Our ref: HA/2021/123102/01-L01
Your ref: LU/76/21/PL

SUB DIVISION OF DWELLING INTO 3 NO. 2 BED FLATS. THIS APPLICATION MAY AFFECT THE SETTING OF A LISTED BUILDING & IS IN CIL ZONE 4 (ZERO RATED) AS FLATS.

71 BEACH ROAD LITTLEHAMPTON BN17 5JH

Environment Agency position

PROPOSED FLOOR PLANS

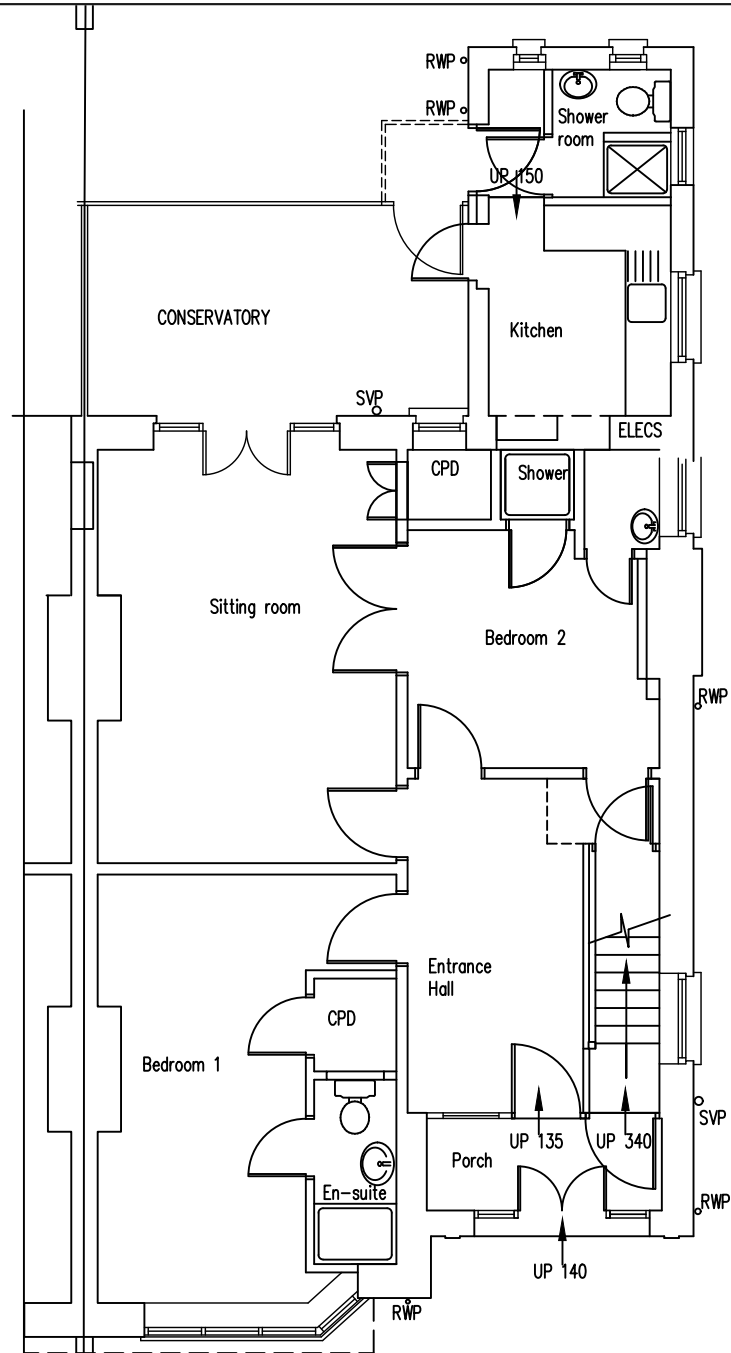
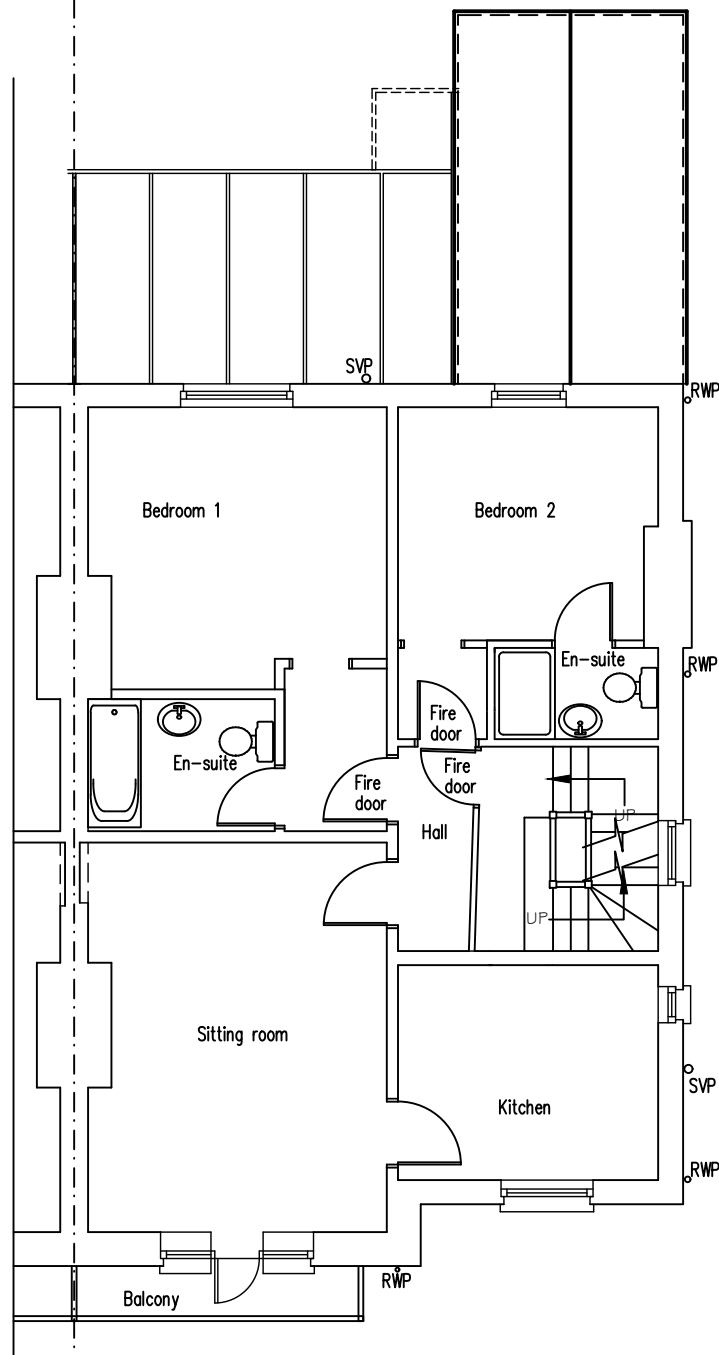
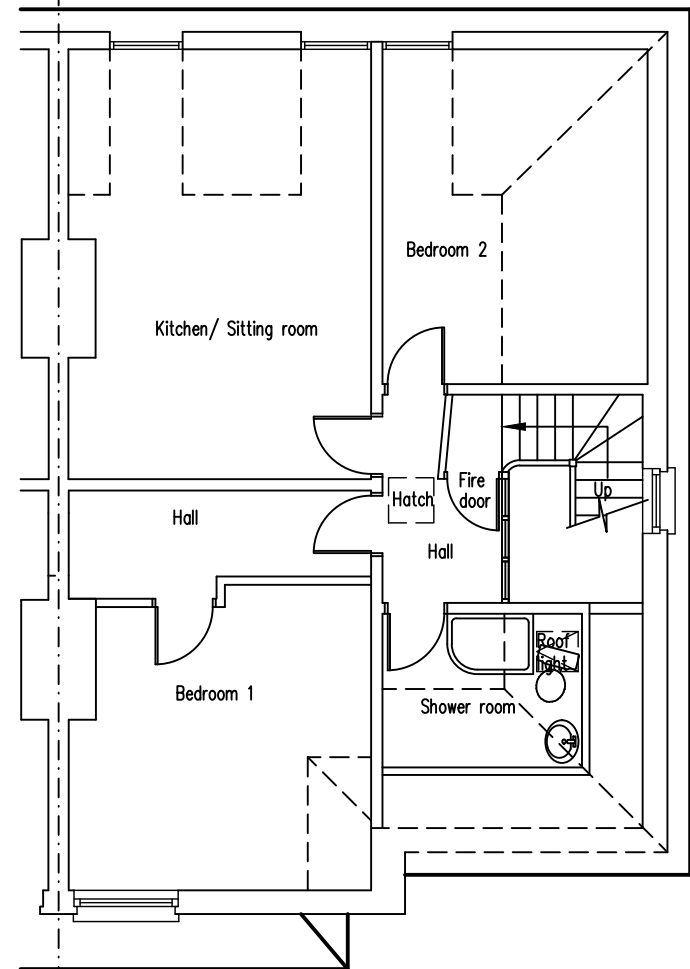
- take the impacts of climate change into account and provide a comparison between finished floor levels and modelled flood levels

To overcome our objection, the applicant should submit a revised FRA and amended plans which addresses the points highlighted above.

We would recommend that sleeping accommodation is placed at least 300mm above the modelled flood levels (0.5% plus climate change allowances 2125), reducing the risk to occupants for the lifetime of the development.
